OXFORDSHIRE COUNTY COUNCIL'S RESPONSE TO CONSULTATION ON THE FOLLOWING DEVELOPMENT PROPOSAL

Application no: 21/01630/OUT

Proposal: Outline planning application for residential development (within Use Class C3), open space provision, access, drainage and all associated works and operations including but not limited to demolition, earthworks, and engineering operations, with the details of appearance, landscaping, layout and scale reserved for later determination

Transport Schedule

Drawing file: 4600-1100-T-060-A - A4095 Howes Lane - Bucknell Road - Proposed Junction - General Arrangement Measurements.dwg Date: Mar 15, 2022 - 12:20pm

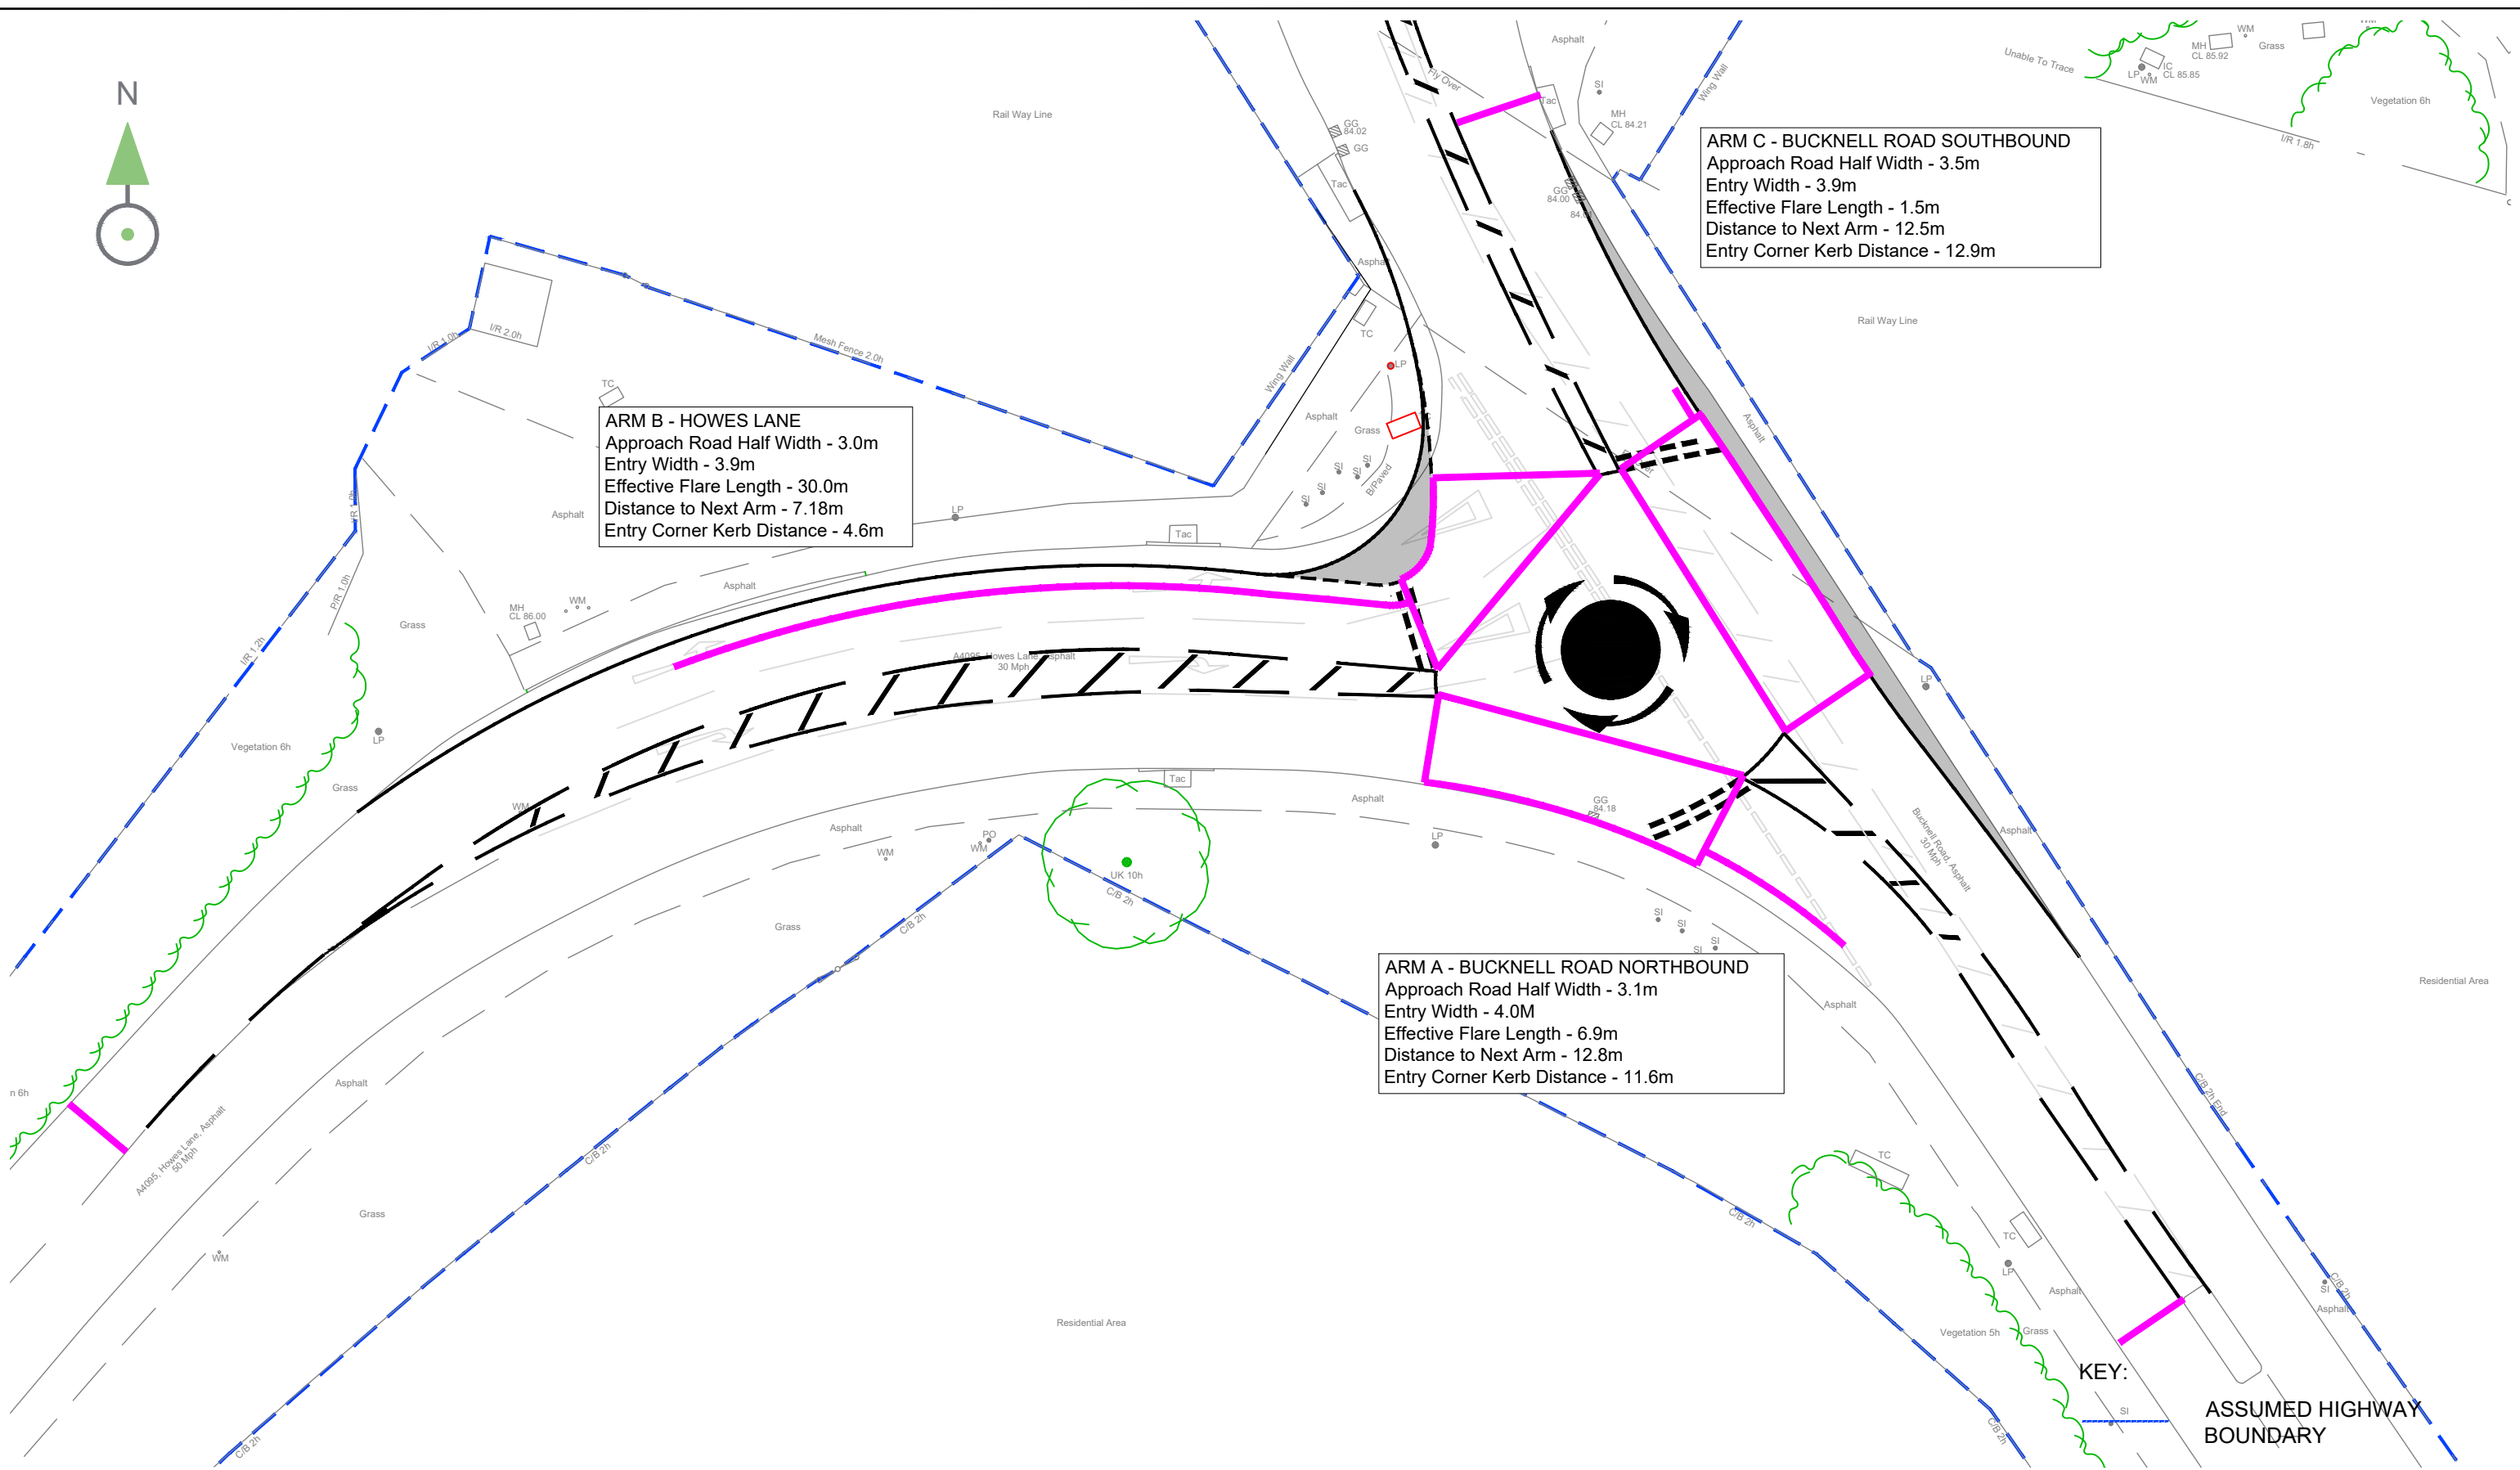
To mitigate the impact of the development on the junction, a mini roundabout scheme has been proposed by the applicant and has been assessed using a calibrated ARCADY model. The results have been used to compare the capacity against the

existing arrangement. However, the ARCADY model has been adjusted to reflect the same calibration applied to the PICADY model of the existing junction arrangement, namely by reducing the demand flows on Bucknell Road by 14%. This is inappropriate, first because with a new, theoretical junction arrangement, calibration does not apply since there are no measured queue lengths to calibrate against, and second because there is no rationale for applying the same factors when the type of junction has fundamentally changed. No reason is given in the technical note for why the calibration factors have been applied to the new junction.

Therefore the conclusion that the mini roundabout would offer mitigation, is unreliable. It is more appropriate to compare the mini roundabout modelled output which uses *unadjusted* flows, with the performance of the existing arrangement (calibrated PICADY output) . The findings suggest that the implementation of a new mini roundabout scheme (as proposed) would only marginally improve capacity at the junction and would not provide a nil detriment mitigation for the development traffic. On some approaches, the queues generated by the roundabout are longer than the predicted queues at the existing junction. The Highway Authority would not accept this scheme as mitigation for the development.
